Dubbo Base Hospital – EPA Additional Information. Acoustics

I represent the sound and vibration business section for Norman Disney and Young. Recently we prepared an REF and SSD DA acoustic assessment report for the Dubbo Base Hospital Redevelopment. The REF has since been reviewed by the EPA. The EPA has issued an assessment of our REF report and has requested additional information as per document DOC12/47285.

The EPA has reviewed the '*Dubbo Base Hospital Redevelopment - Acoustic Assessment*' (AA) prepared by Norman Disney & Young dated 11 July 2012 (Revision 3.0). This report forms part of the Review of Environmental Factors (REF) for the project prepared by JBA Urban Planning Consultants dated July 2012 (Ref. 12151).

Figure 6-1: Extents of the recommended noise wall to control car park noise

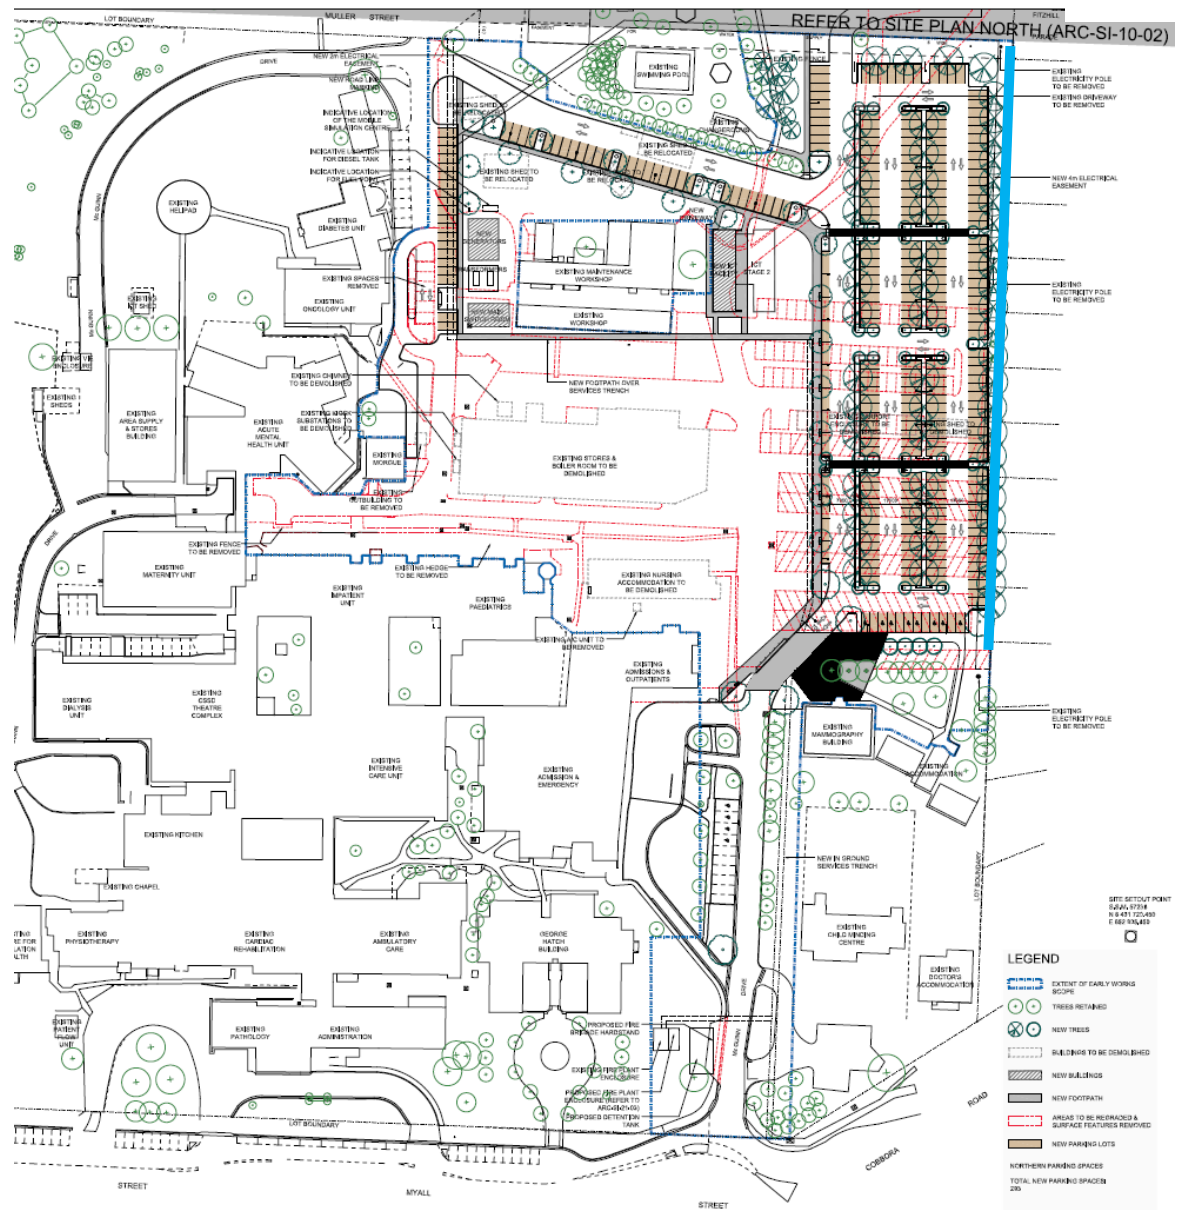
-
- Section 6.3 of the AA presents a noise wall design to mitigate noise impacts from the revised car park arrangement. It appears to the EPA that the noise wall design may not sufficiently shield residences on the northern part of Leonard Street. An additional length of noise wall extending west from the northern end of the designed wall, for the width of the car park, could assist in this regard, if required. Alternatively, the AA should explicitly show that all residences to the east of the development (including the full length of Leonard Street) are adequately protected by the noise wall shown in the AA.

An existing fence of approximately 1.5 m currently runs along the entire eastern boundary. The recommended noise wall was modelled in conjunction with the existing fence. The recommended noise wall controls noise emission to those residences directly adjacent to the carpark. The existing fence controls noise to those residences to the north and south of the carpark. For this site, therefore, the noise wall does not need to be extended as suggested.
